Planning Application Ref: **AW/107/21/T**

Location: **49 Chawkmare Coppice, Aldwick, PO21 3SP**

Description of works: **Mature Monterey pine (T1) - Canopy reduction of up to 15% to remove dying branches**

Monterey Pine in rear garden of No. 49.
Chawkmere Coppice - P021 3SP

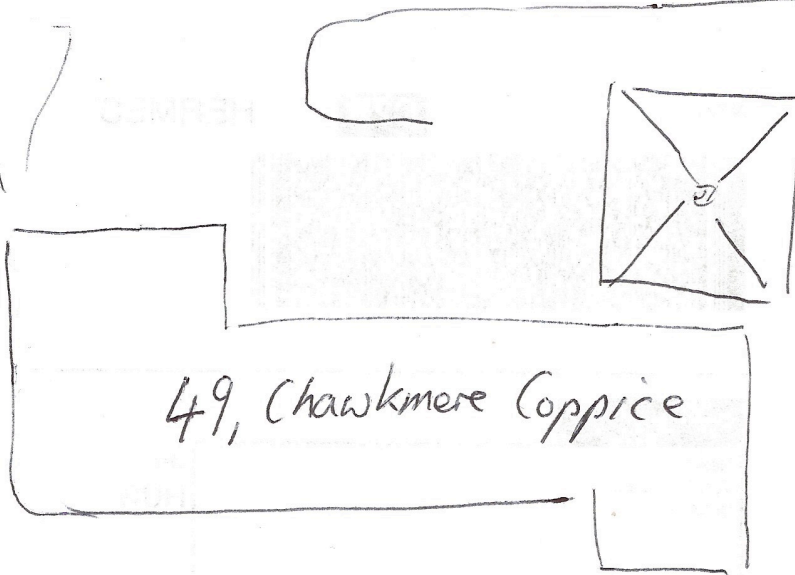
- Outwardly and from distance (roadside) this tree appears to be in a fair physiological state (and assumed to be so in the absence of any information/evidence provided to the contrary). It is a large and prominent tree, of obvious public amenity and landscape value.

- The applicant employed Arun Tree Company Ltd to assess the tree and they have not reported any obvious structural defect or disease, other than the presence of dying branches throughout the crown. The presence of deadwood and declining branches may be characteristic of perfectly healthy trees of this type or associated with a pathogen and/or environmental factor.

- Whilst an understanding of the work proposal has been reached, following correspondence between planning department and applicant; for the benefit of all interested parties, it should be acknowledged that the 'Description of works' is open to interpretation. The intention is clearly to undertake a canopy thin (maximum 15% of current volume removed) rather than a canopy reduction (where typically the height and spread of the tree are reduced). The latter operation being entirely inappropriate.

- This tree requires careful management that respects its age and vulnerability to environmental changes and disease progression.
- The principle of the work proposal is sound and for many trees in similar locations would be supportable. It would be intensely onerous and perhaps impractical to comprehensively specify, consequently we have only a statement of intent. Should we approve such an application, we would cede control over the operation (extent and location of crown material removed) to the applicant and their appointed contractor. That is not a satisfactory position for the local planning authority to be in, where the tree is of such high value.

- I recommend **REFUSAL** for this application.
